**Consultation Response from KC,
Trees**

2025/90611 2, Kaffir Road, Edgerton, Huddersfield, HD2 2AN

Erection of extensions and alterations (within a Conservation Area)

Date Responded: 07/04/2025

1 Site as Proposed
1 : 100

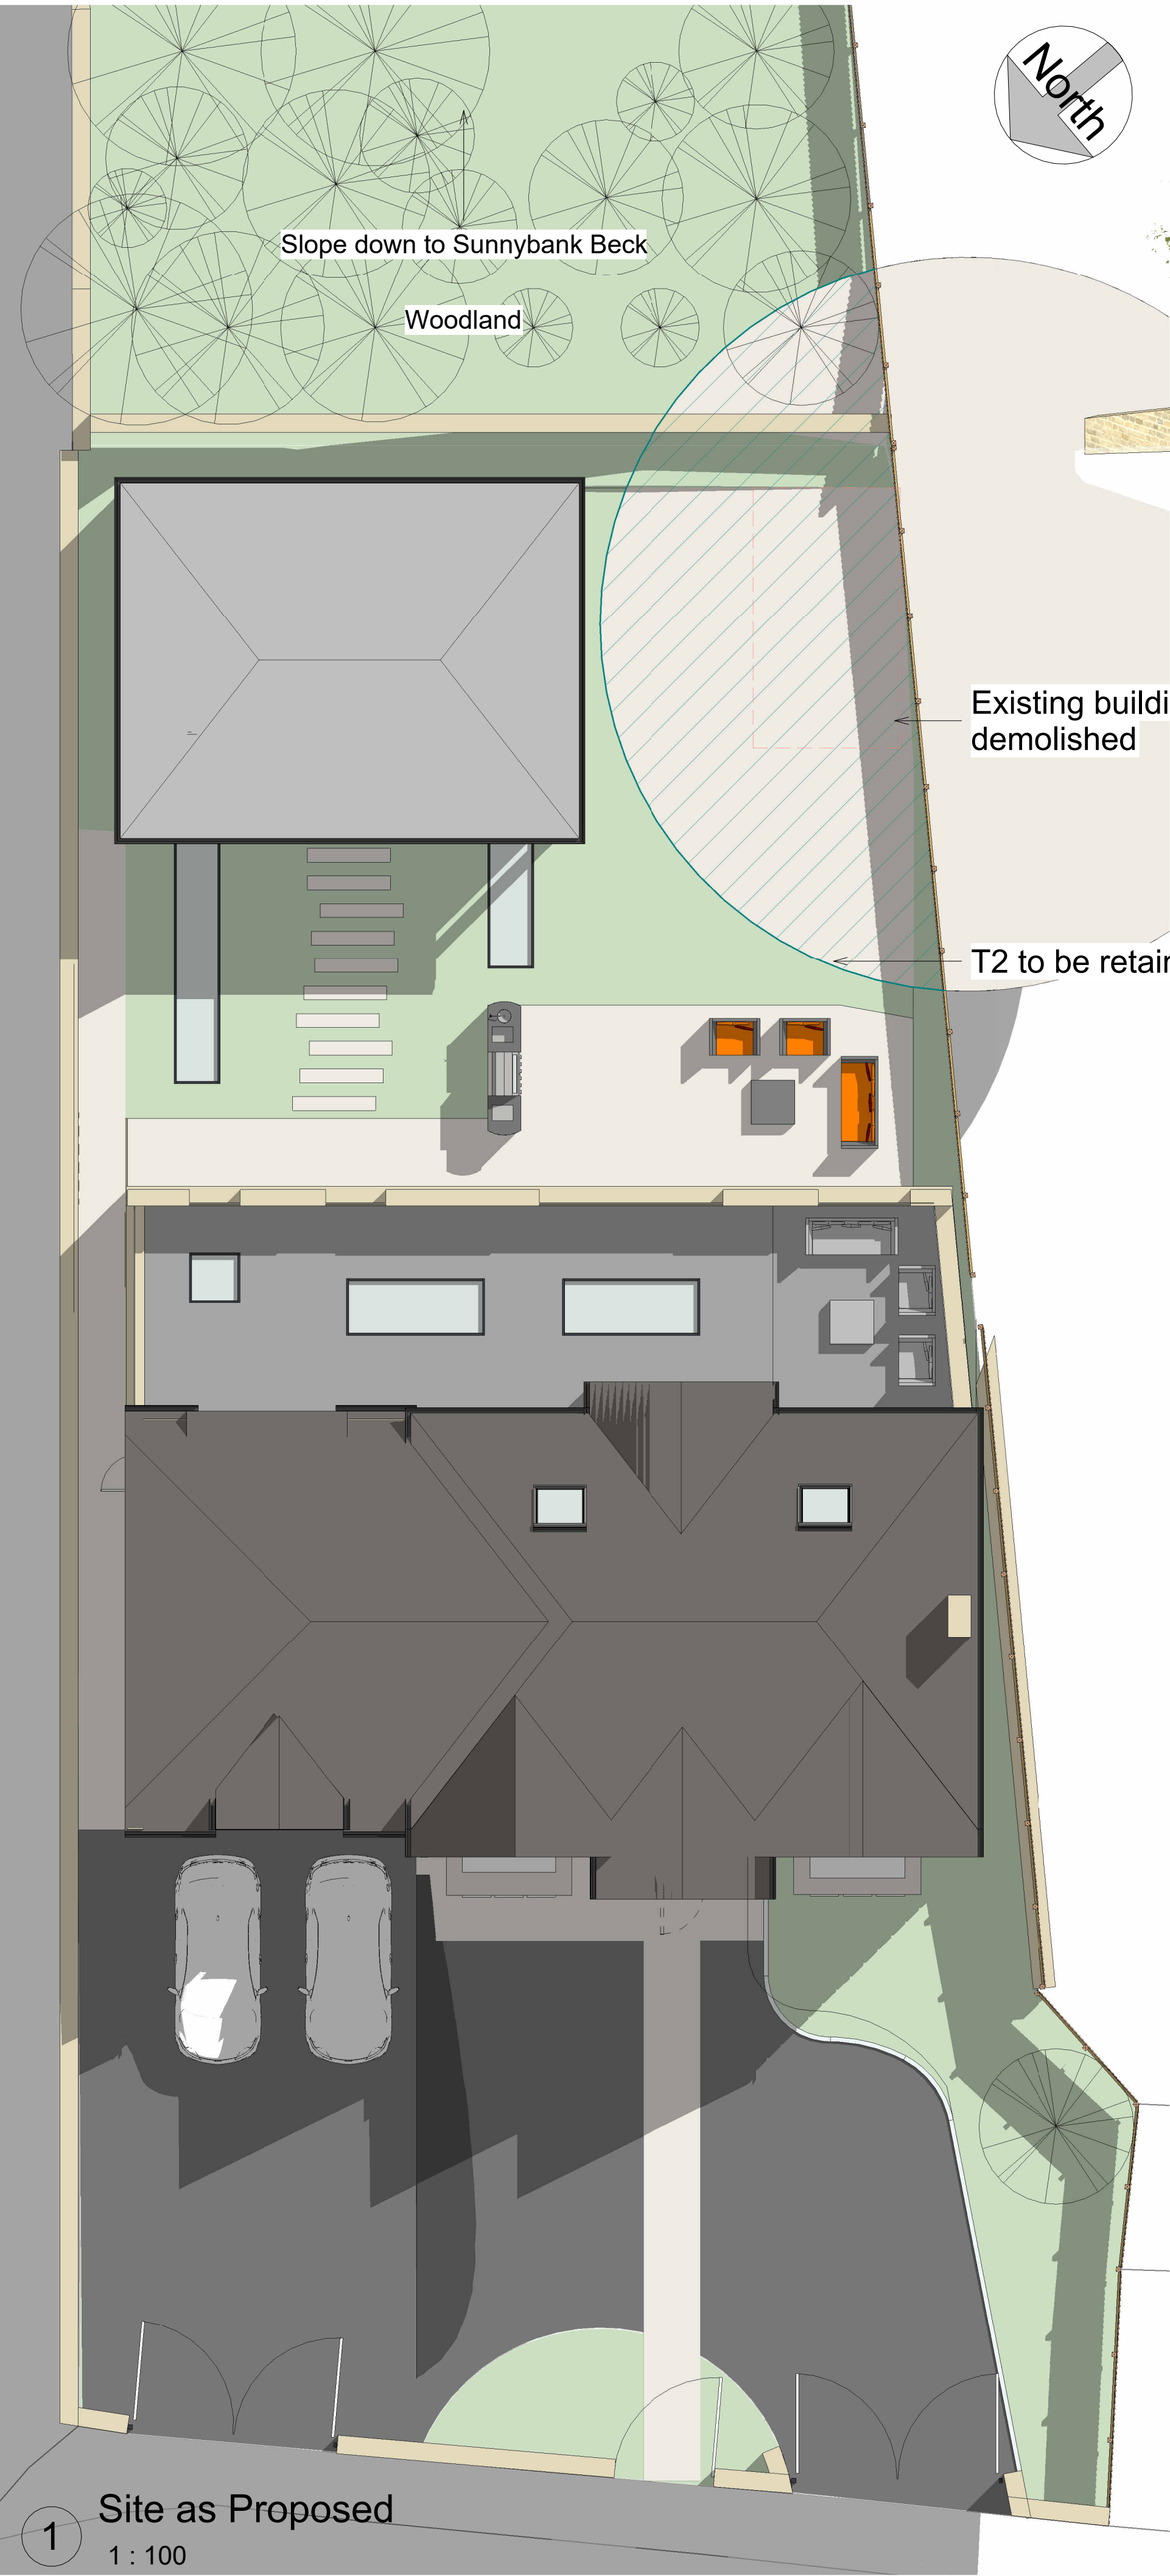
Due to the close proximity of the proposed plans and Arboricultural Impact Assessment would need to be submitted in order to conclusively know what the impact on these protected trees are. Although the plans may be clear of the canopies the root protection area of these trees could spread into the site.

There is a holding objection until the above information is submitted for review.
